Site Plan Drawing_V2.pdf Markup Summary

VENETUCCI FARMS

A PORTION OF THE SW $\frac{1}{4}$ OF THE SW $\frac{1}{4}$ OF SECTION 11 AND A PORTION OF THE NW $\frac{1}{4}$ OF SECTION 14, EL PASO, COUNTY
 5202 HWY 85-87, 5210 HWY 85-87, 5304 HWY 85-87 & 5304 HWY 85
SPECIAL USE PERMIT - BUSINESS EVENT CENTER

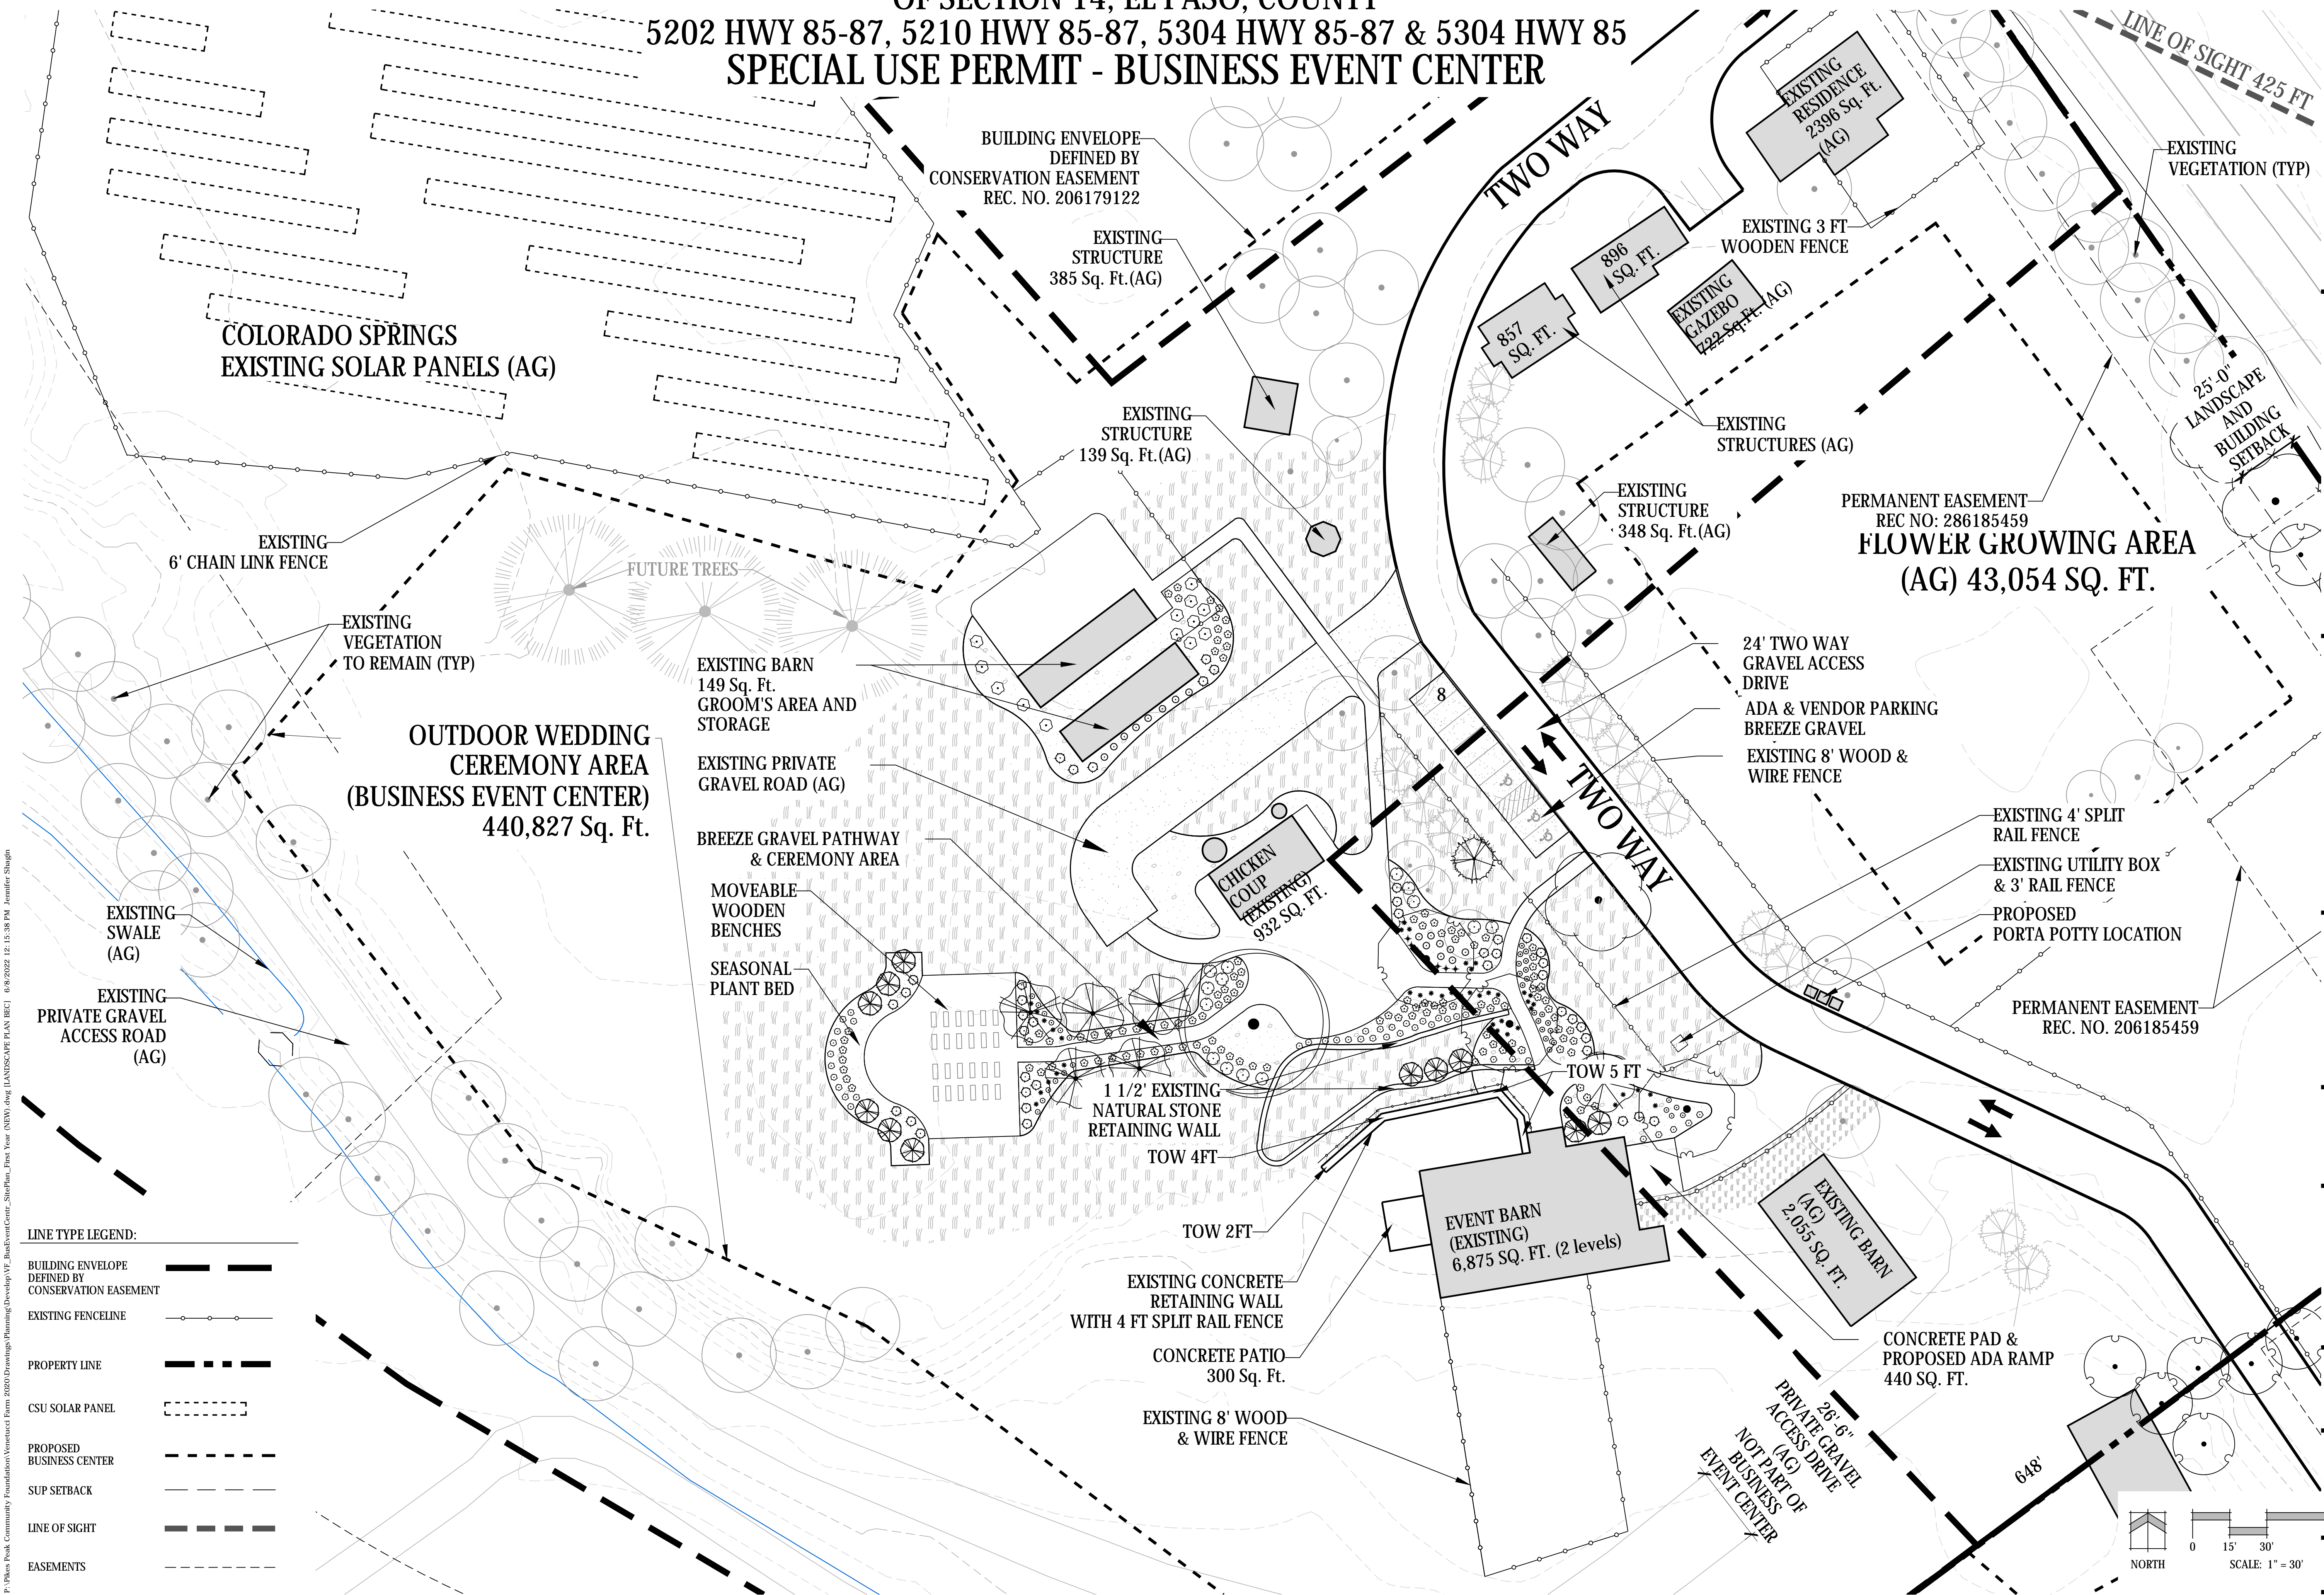
Call out the floodplain and drainage facility on plan.

Call out the floodplain and drainage facility on plan.
The blue line shown on this plan represents an irrigation ditch utilized for farming operations with water flows controlled by the Pikes Peak Community Foundation
